August 4<sup>th</sup>, 2023

Project Name (VA-23-0004) Kosar Setback Variance

31 Eagle View Dr
Parcel 902134
7-10-23

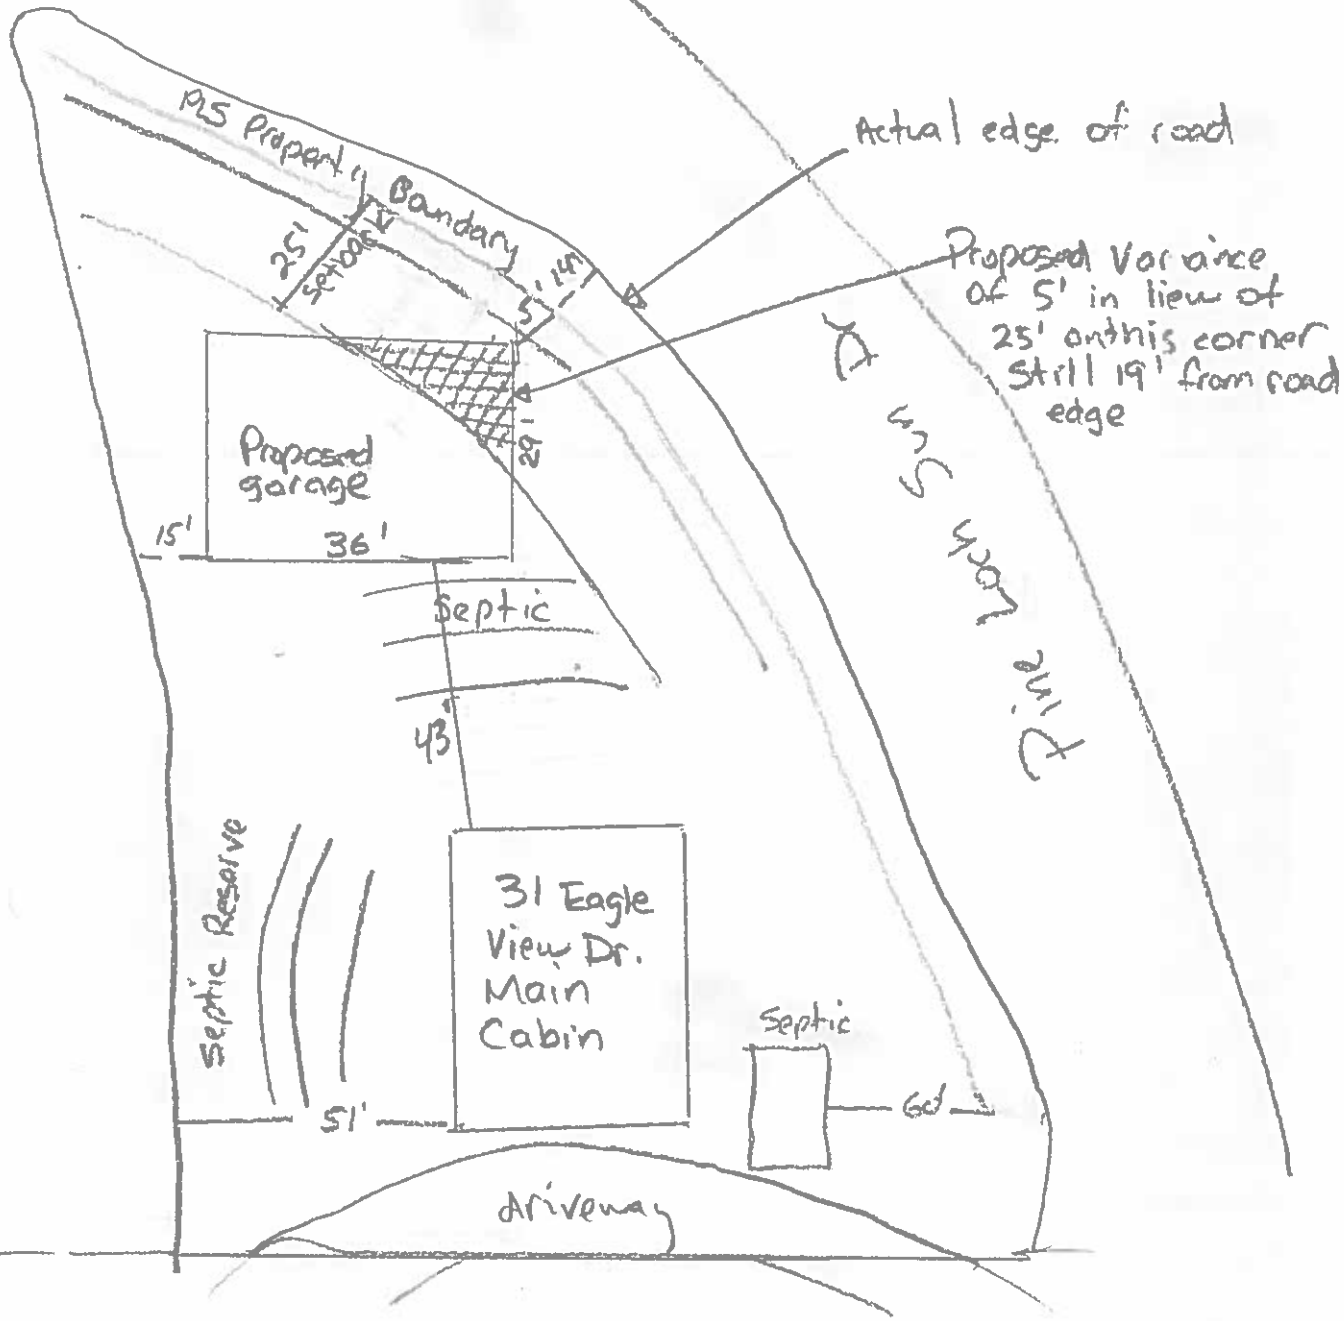
The Board of Pineloch Sun Beach Club would like to express our objection to the proposed setback variance. It is the position of the Association, that placing a building within 5 feet of the road boundary may negatively affect any future road improvements. Pineloch Sun Drive is the main road through Pineloch Sun, one of the busiest roads in PLS. While there are no clear plans for widening the roads at the present time, the membership has expressed interest in the future development of our roads. Having a permanent building within 5 feet of the property line will limit our options.

The safety of our members should also be considered. While our roads are closed for much of the winter, we still have several weeks of icy slick roads that members navigate. Having the corner of a building just 5 feet away from the potential road is concerning.

Pineloch Sun does not object to a 15-foot setback as originally proposed. We do, however, object to granting a variance to 5 feet.
